Zachariah Denton
Planning Officer

We have also had a slight change of heart on the timber cladding and would like to propose a vertical charcoal timber cladding instead of horizontal. I have attached the revised drawing, could you let me know if it is possible to swap out the drawing for this one?

--
Adam Casey **ARB RIBA**
Director

Drawing
Proposed Elevations

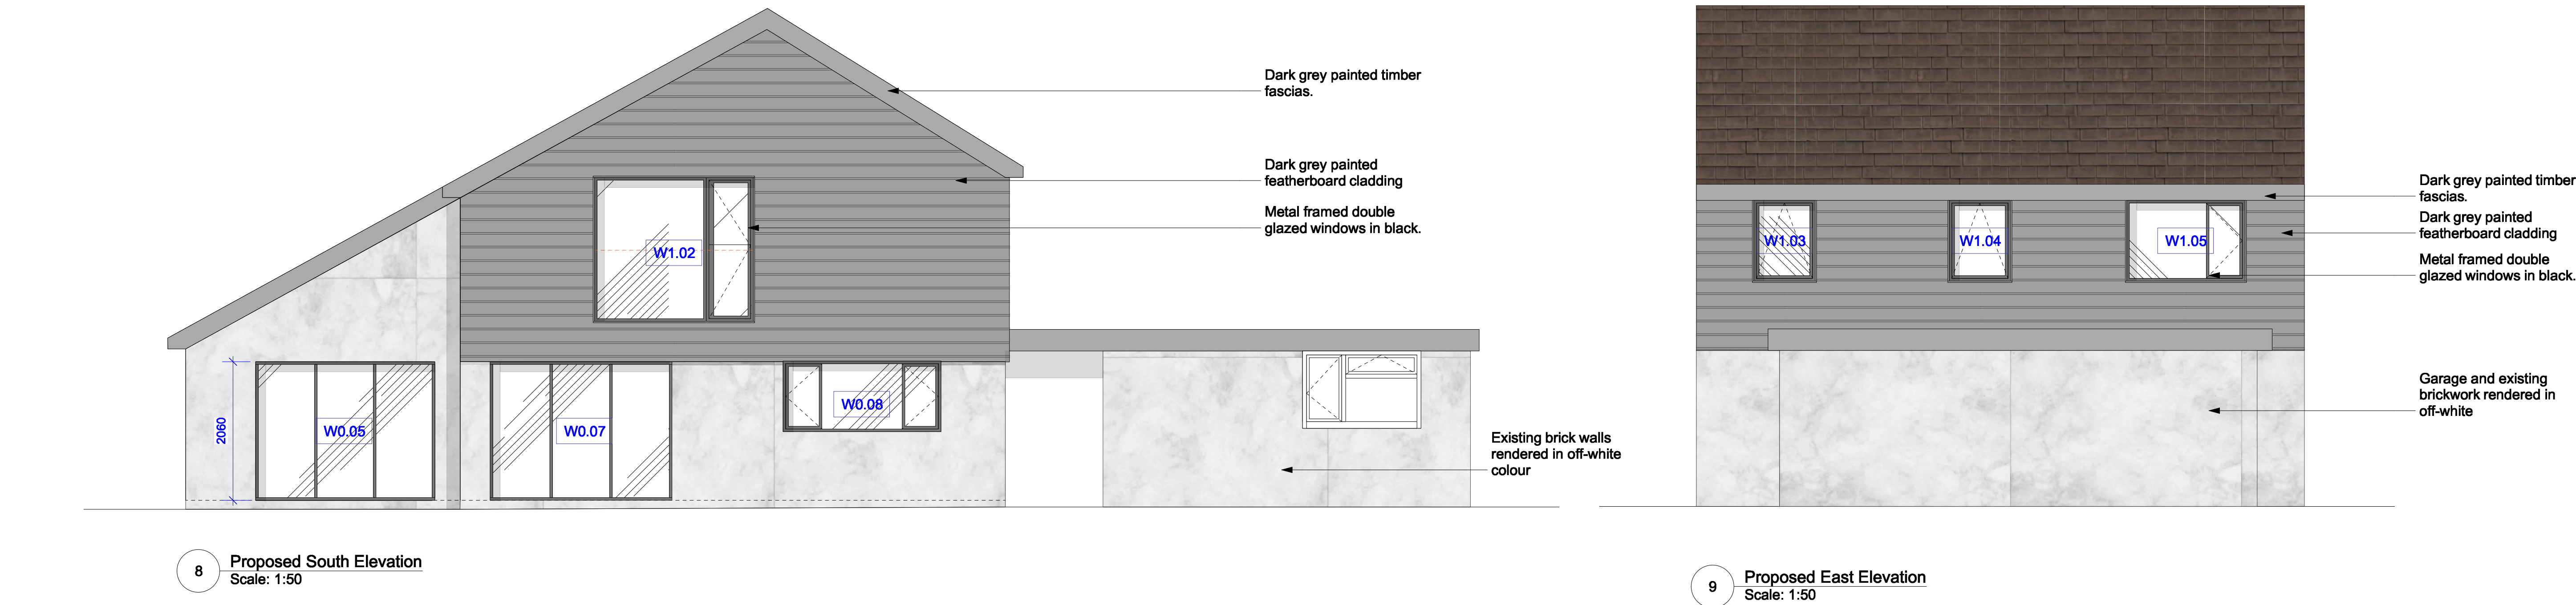
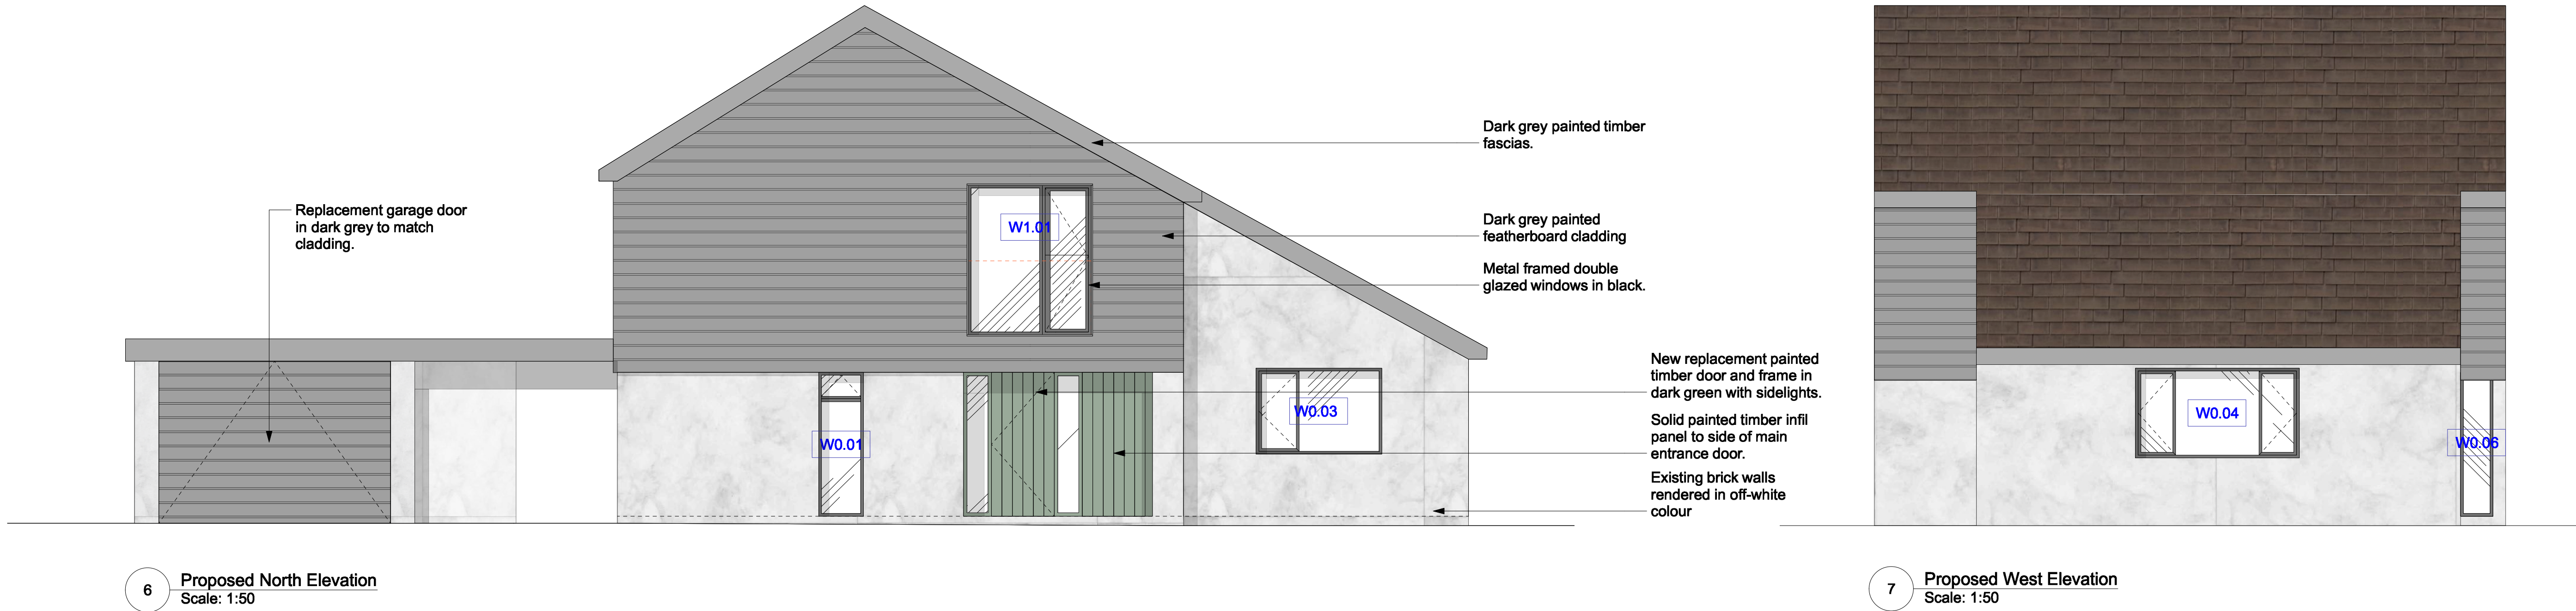
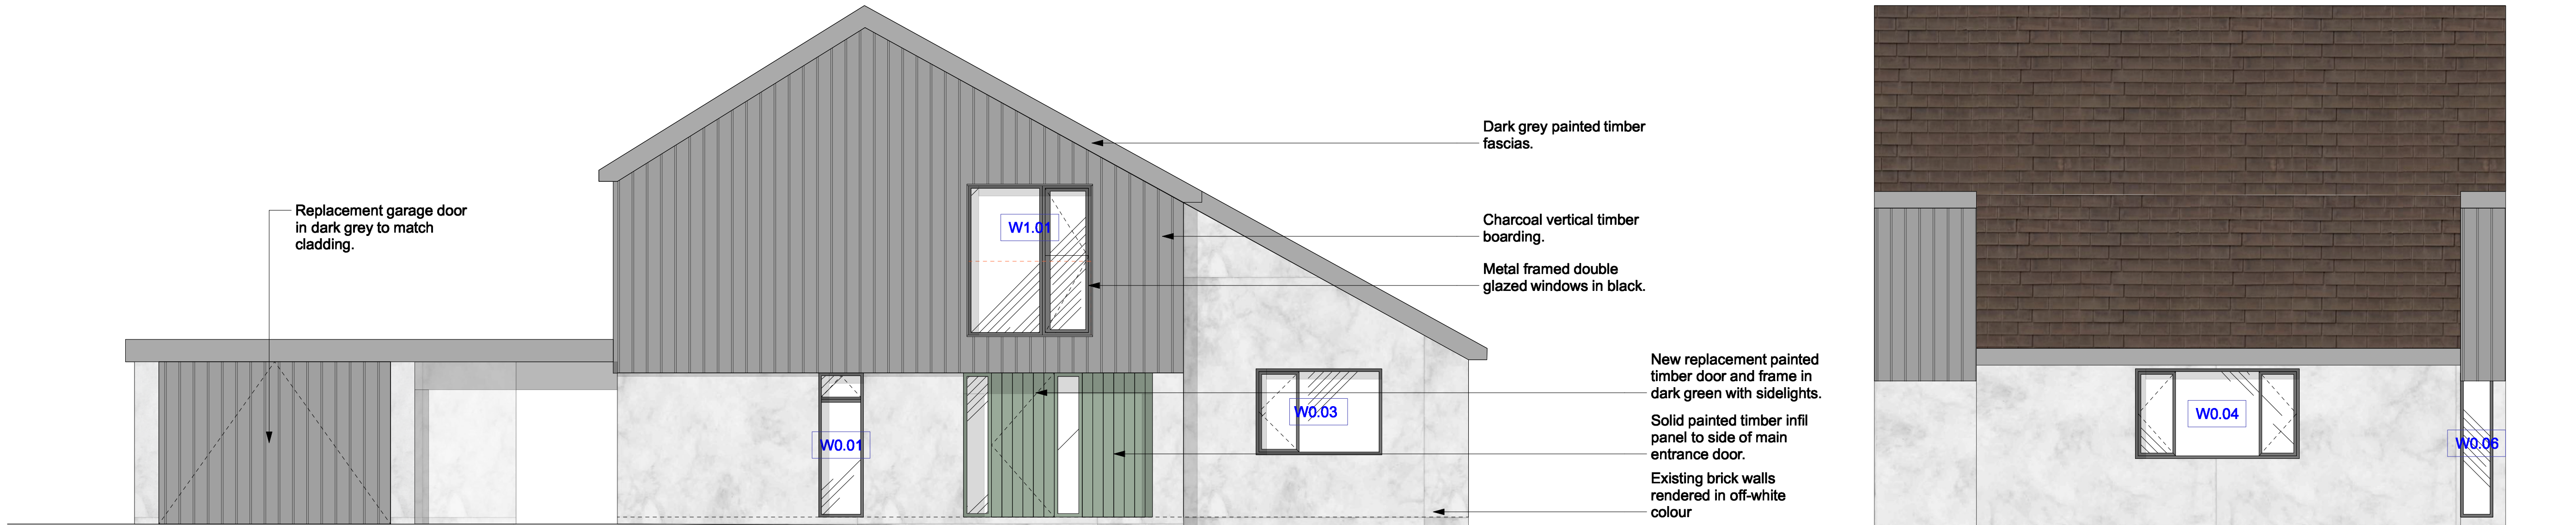
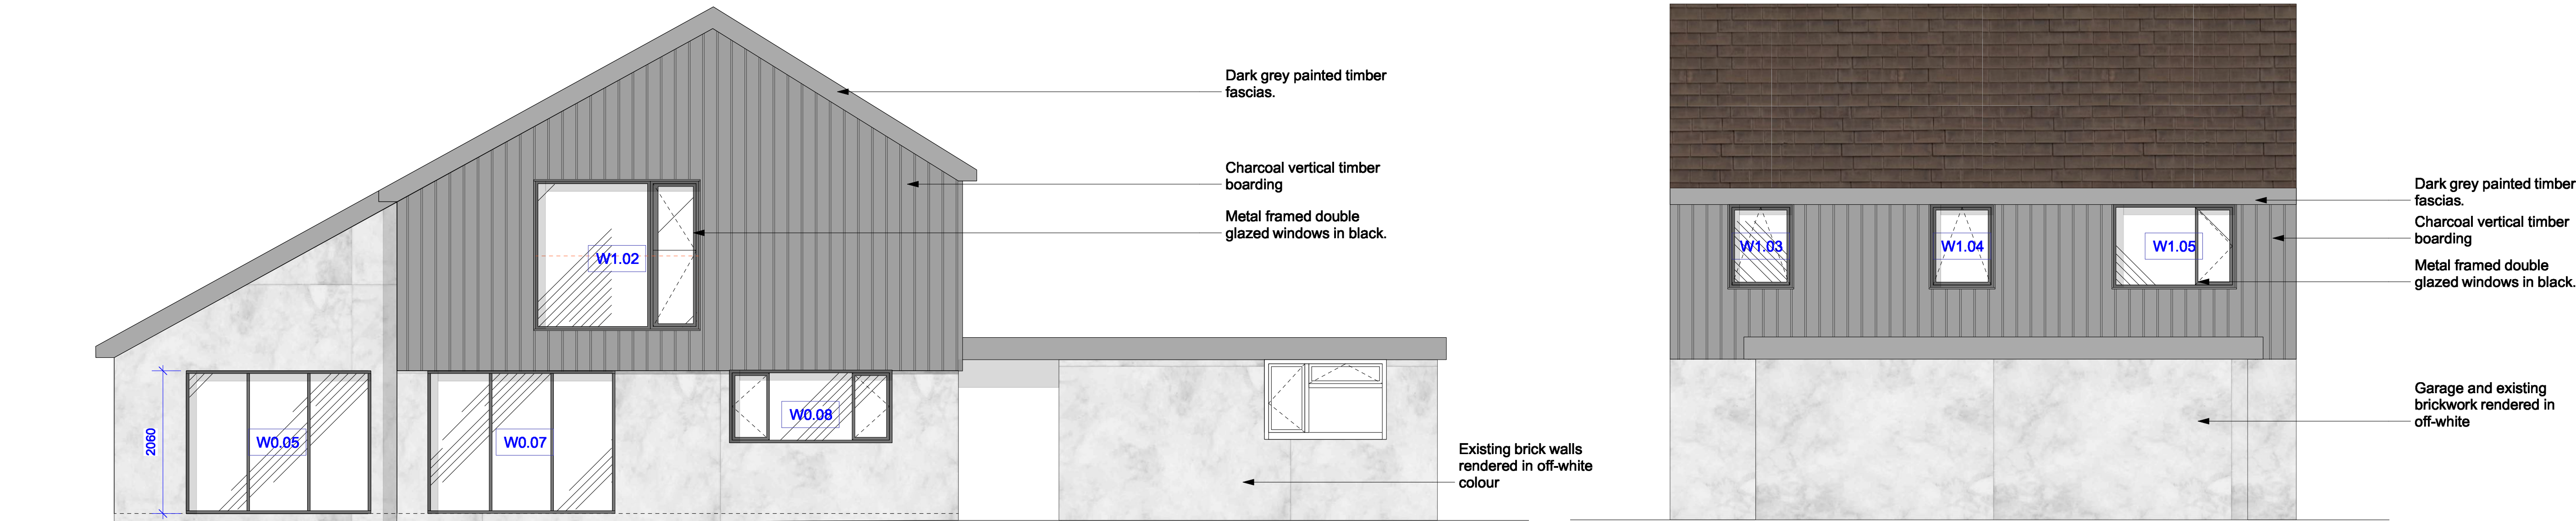
Please can the elevation plan supersede the existing elevation plan. Also please send the 21 day parish council notification, no other consultation will be necessary.
